**Re: NuVue at 1171 Jaffa Rd. NE  
Erosion and Sediment Control Plan  
Engineer's Stamp Date 2/29/24 (L22E011)**

Based upon the information provided in your submittal received on 3/4/24, the above-referenced ESC Plan can't be approved until the following comments are addressed. Generally, the SWPPP (SWPPP maps and ESC Plans) must be prepared in accordance with good engineering practices by qualified (e.g., CPESC-certified, engineers with appropriate training) erosion control specialists per CGP 9.6.1.c.iii. You must implement erosion and sediment controls in accordance with the requirements of CGP 2.2 to minimize the discharge of pollutants in stormwater from construction activities.

Sheet Title:  
**Landscape Plan**

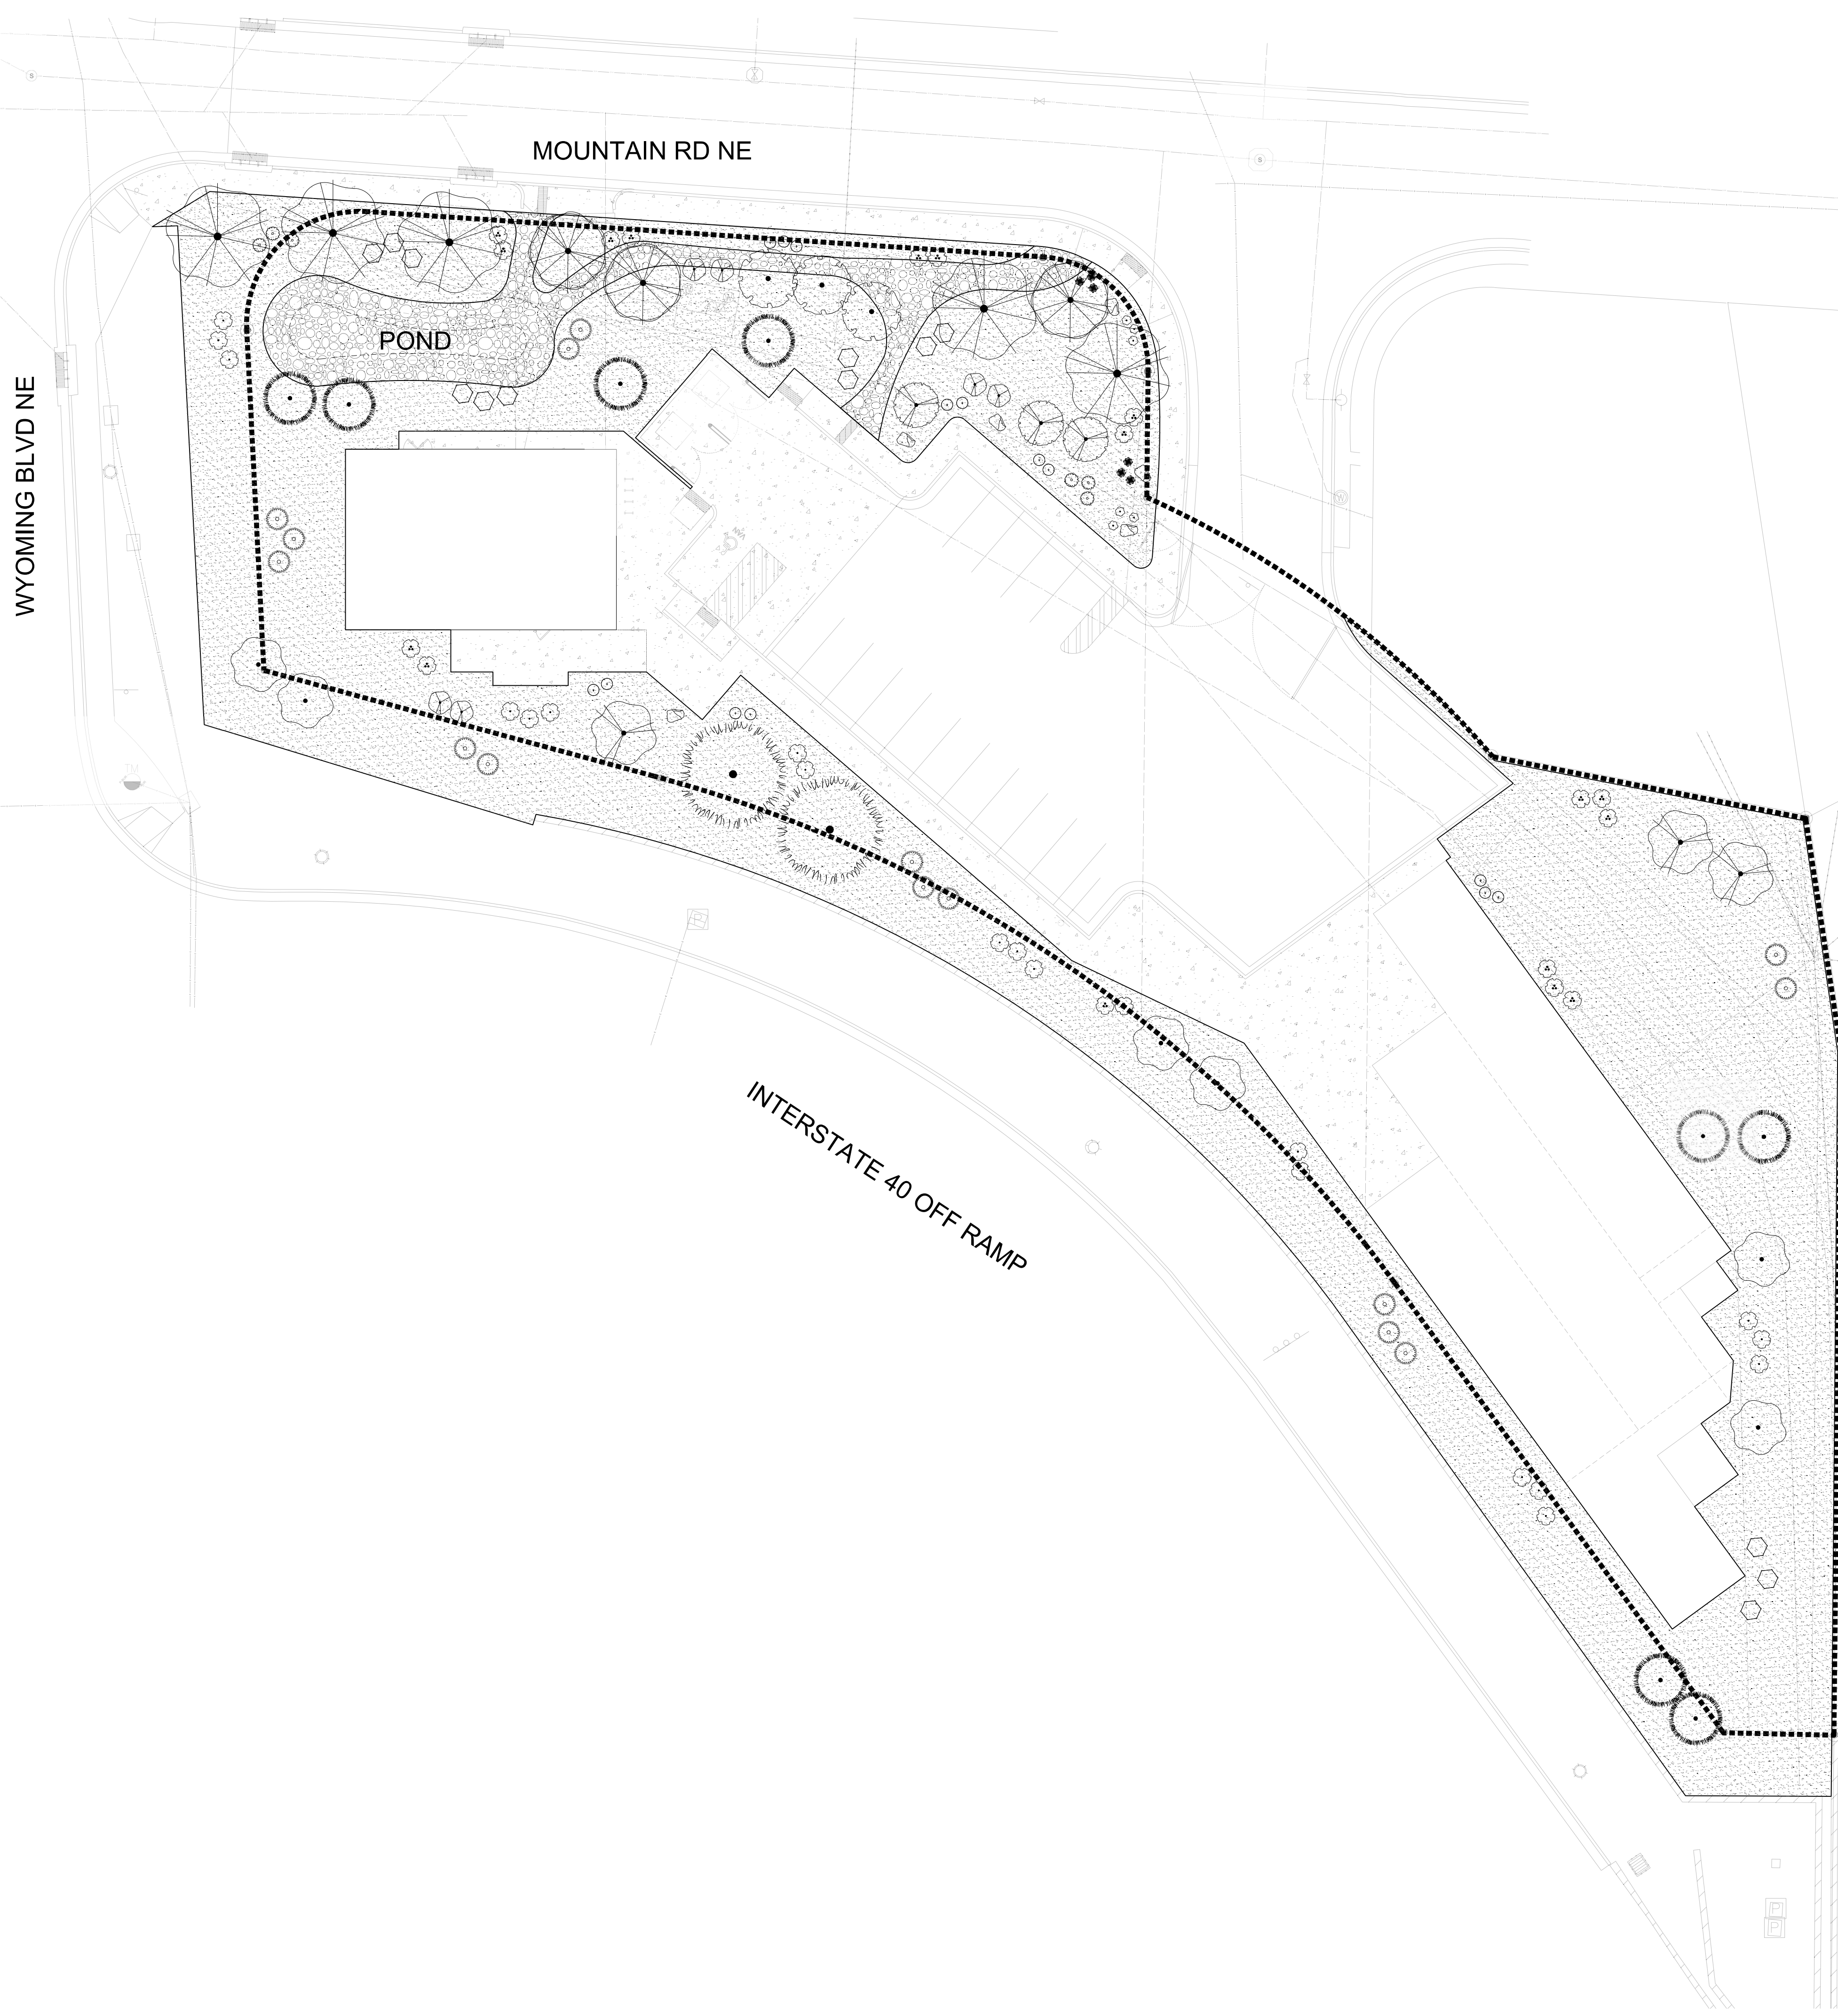
3. The SWPPP must include site-specific interim and permanent stabilization per CGP 9.6.1.c.i. The Landscape Plan can be used to satisfy this requirement and should be submitted separate from the ESC Plan with the application to the Stormwater Quality Section of the Planning Department and they should be included in the SWPPP. Provide a specification on the ESC Plan for any disturbed areas not covered by the Landscape Plan.
